In reply please quote: 20/05386

**APPLICANTS RESPONSE TO SUBMISSION – 6 JOHNSTON CRESCENT, HORSLEY PARK – ESR HORSLEY LOGISTICS PARK (SSD-10436)**

LOT 201 STORMWATER DRAINAGE PLAN
SCALE 1500

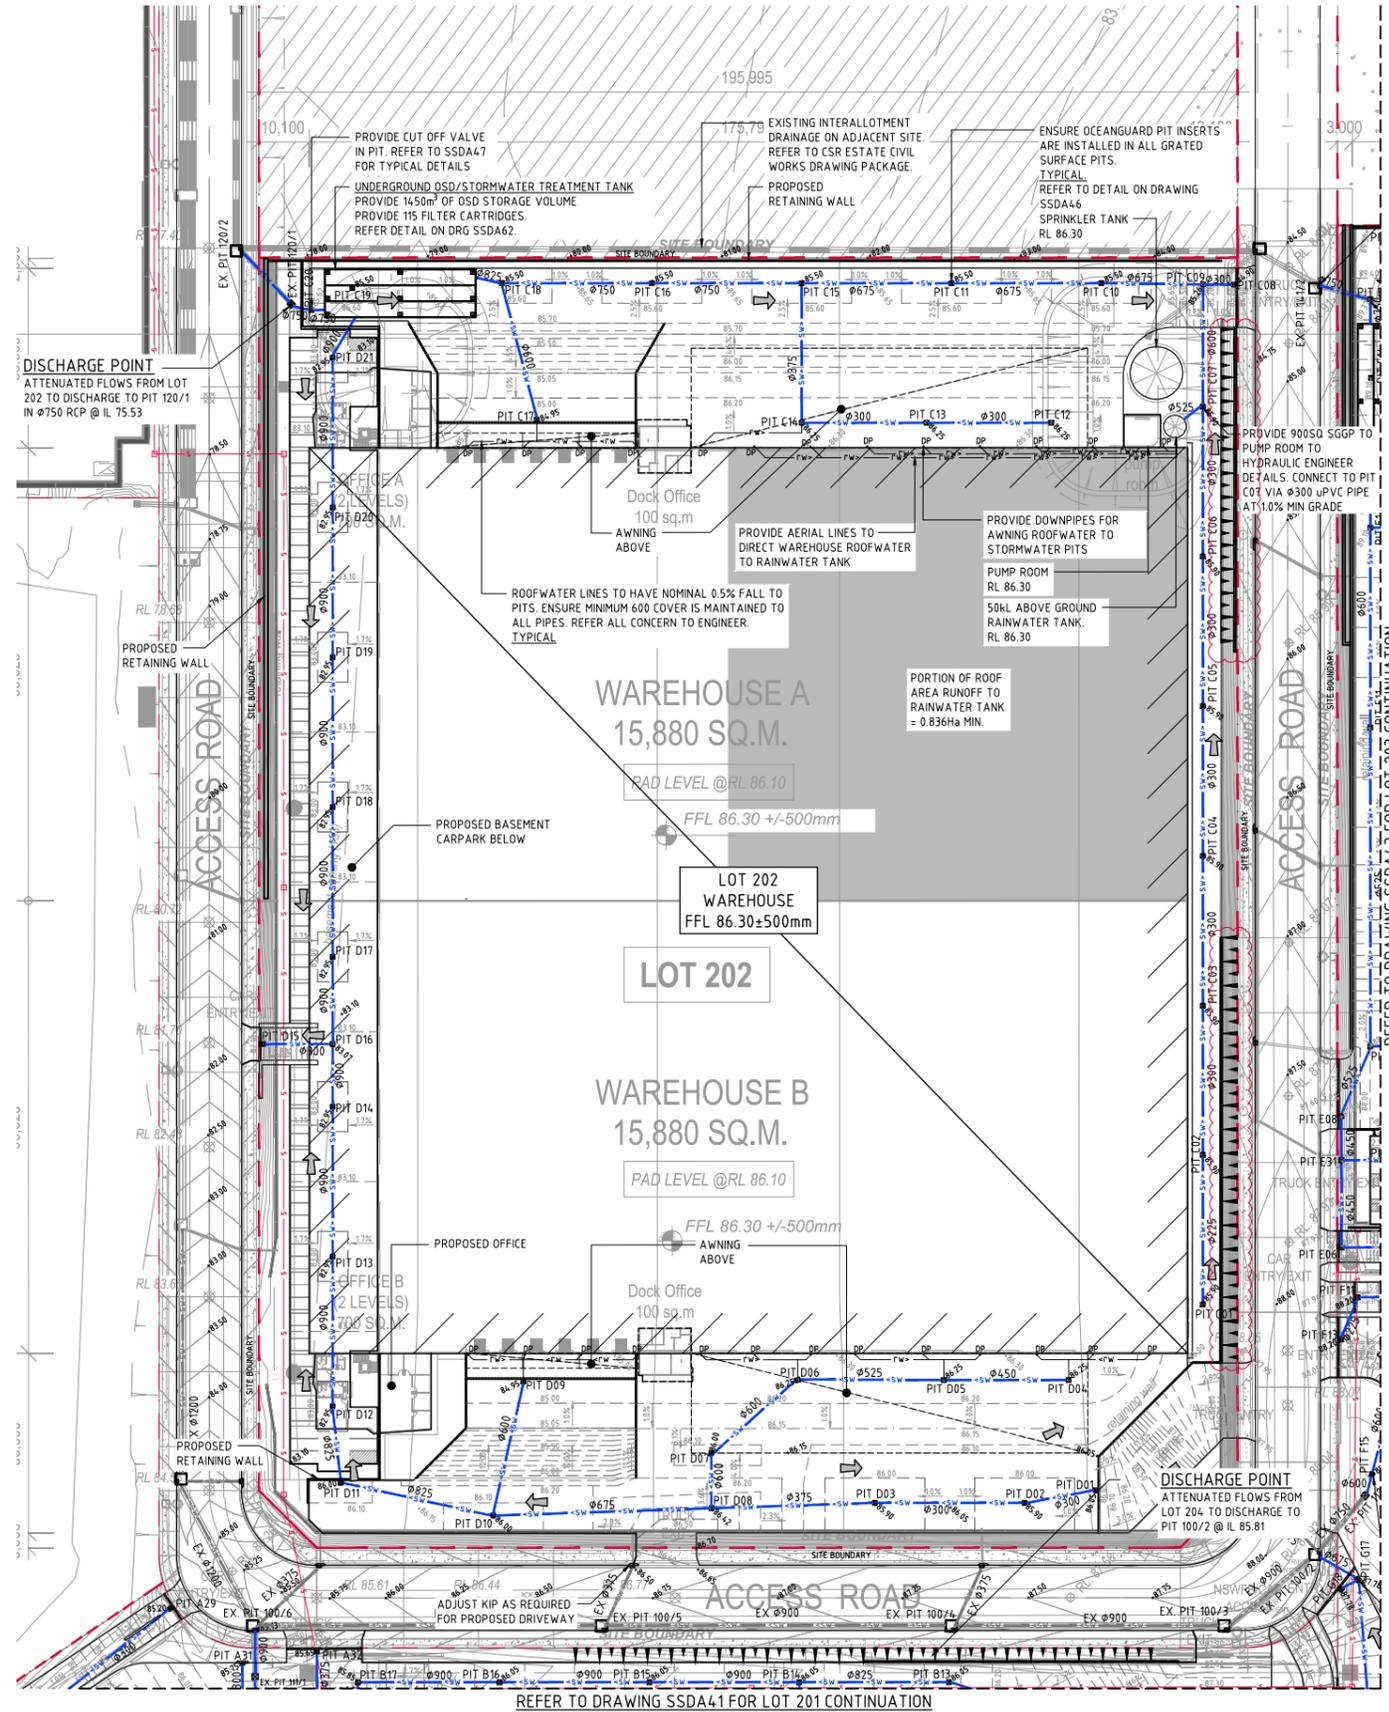
As previously requested, the existing pipe details including the invert levels of the pipes within the access road at all stormwater connection points shall be shown on the stormwater plans. The obvert level of the pipe in the access road shall be taken as the tail water level for the design of the OSD system.
